TOWN AND COUNTRY PLANNING ACT 1990 PRIOR NOTIFICATION

Reference:	H16-0040-21	Date of Decision:	4th March 2021
Applicant:	Mr T Burrows 8-9 Red Lion Street Stamford Lincs PE9 1PA		
Location:	South Drove North Spalding		
Description:	Change of use from barn to residential dwelling

South Holland District Council hereby give notice that this application has been REFUSED for the above proposal for the following reason(s):

SITE PLAN & PROPOSED SITE LEVELS
1:500

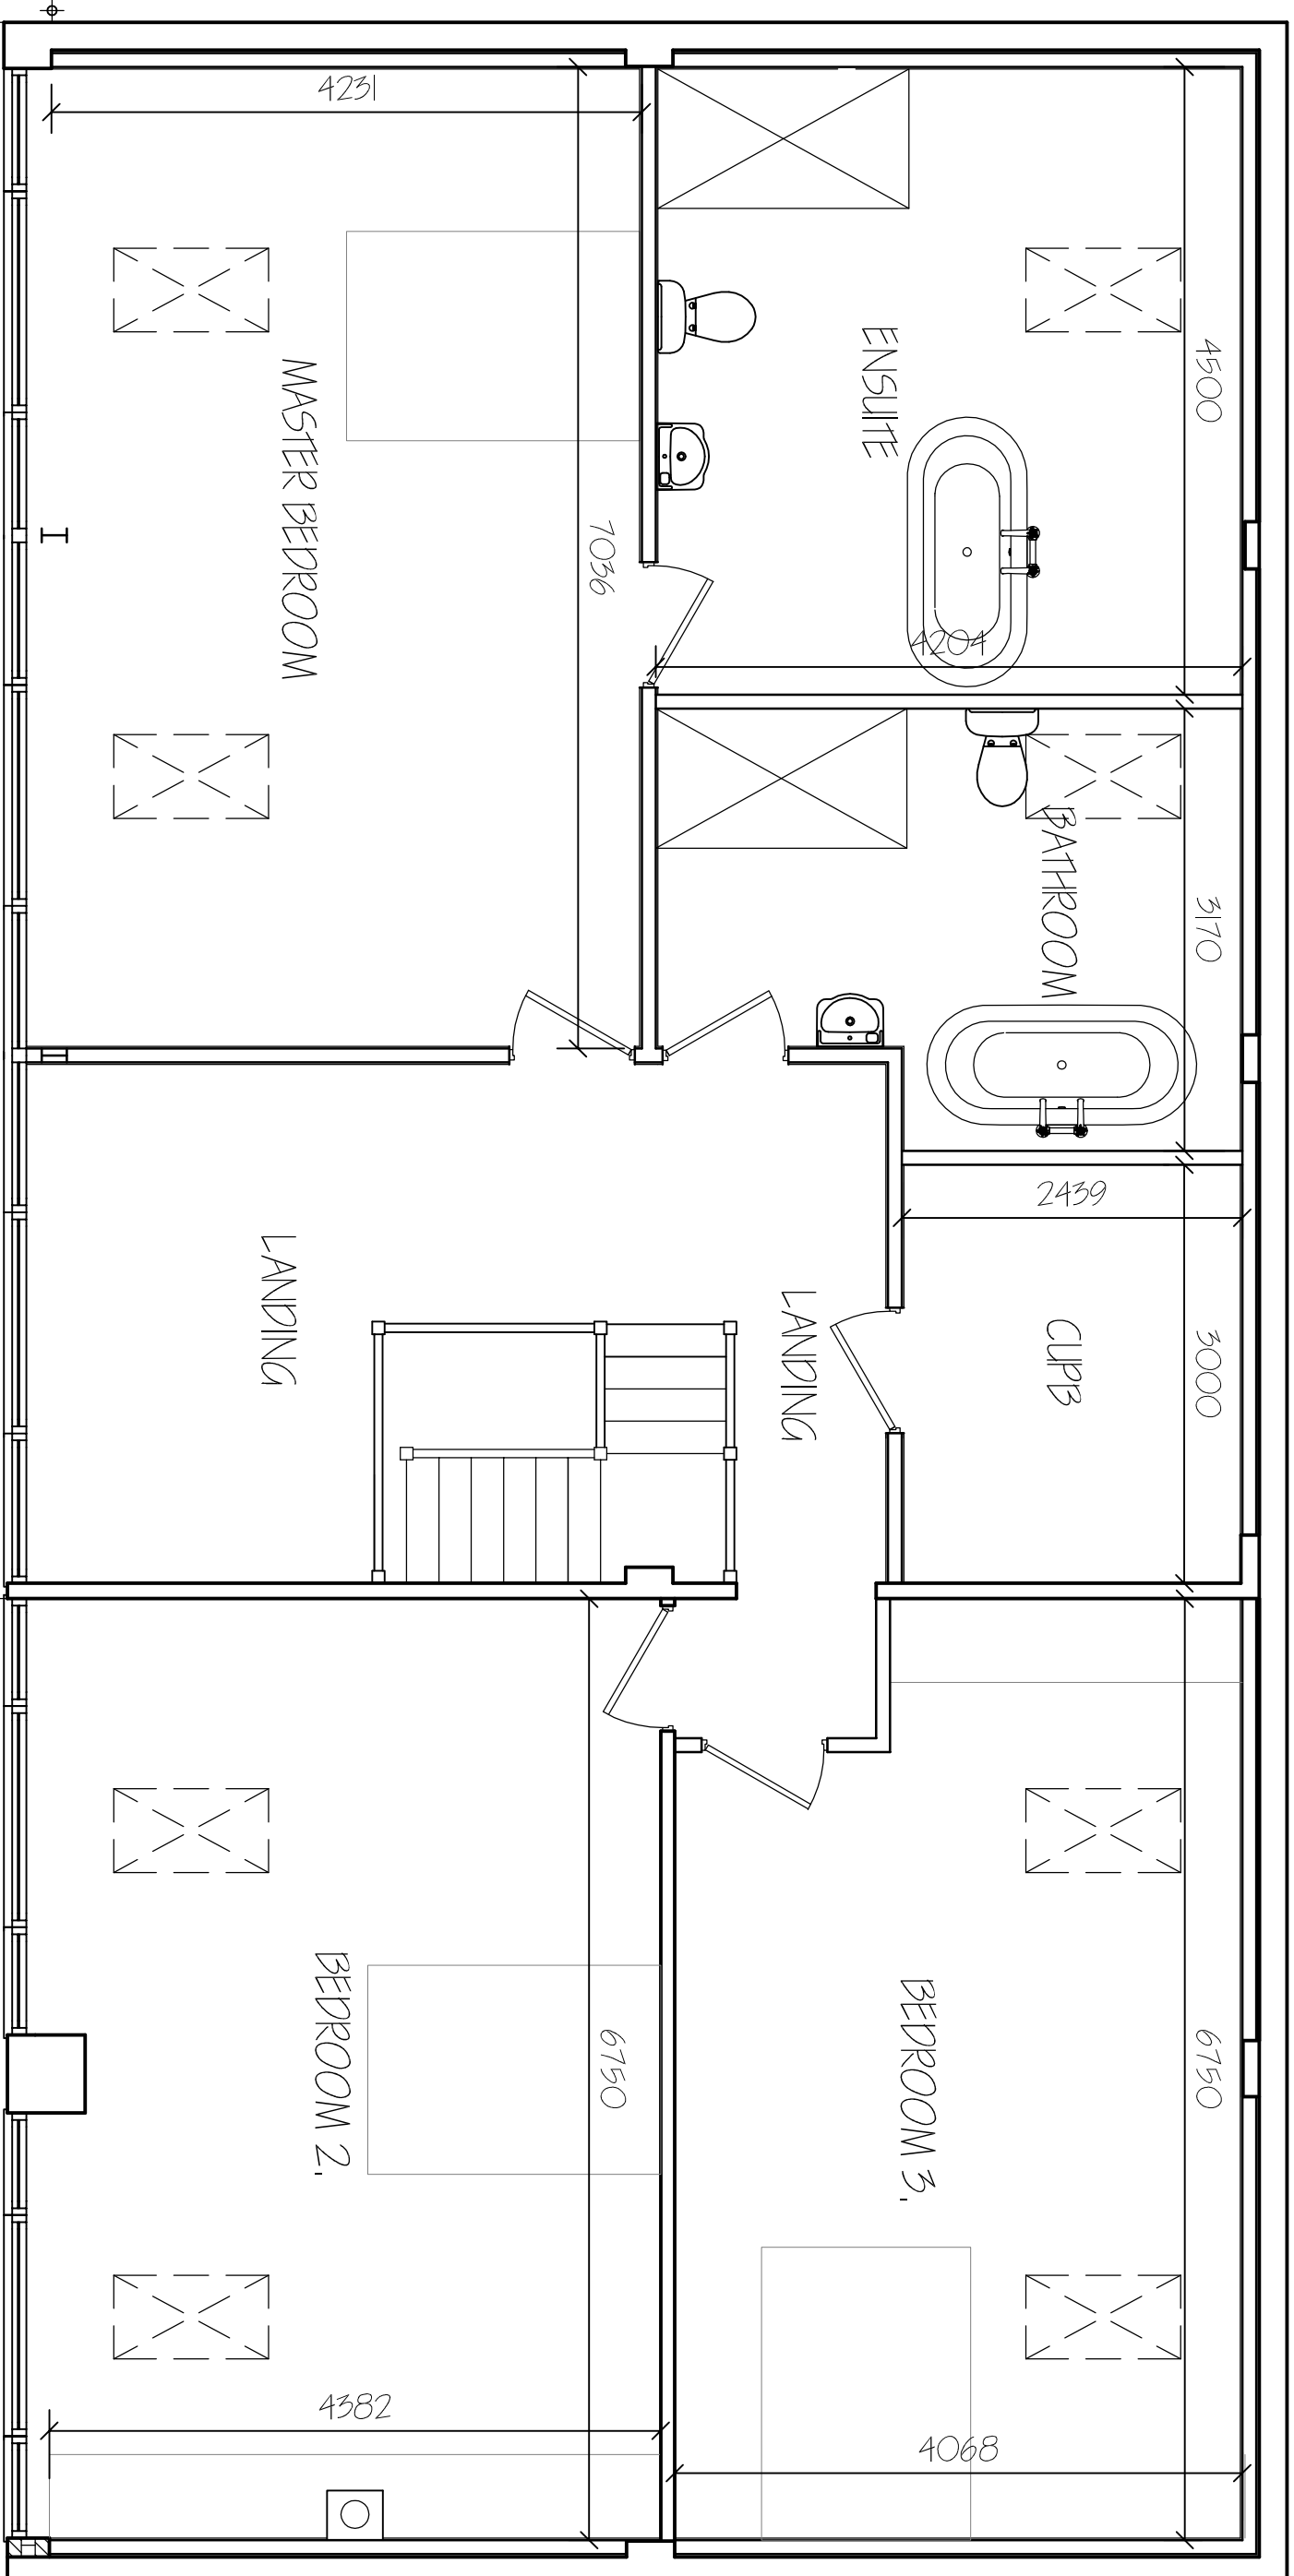
- 1 The proposed works fail to satisfy the requirements of paragraphs Q(a), Q.1(g) and Q.1(i) of Class Q of Part 3 of Schedule 2 of the Town and Country Planning (General Permitted Development) Order 2015 (as amended). This is because the area of residential curtilage beside or around the building would exceed the land area occupied by the agricultural building.
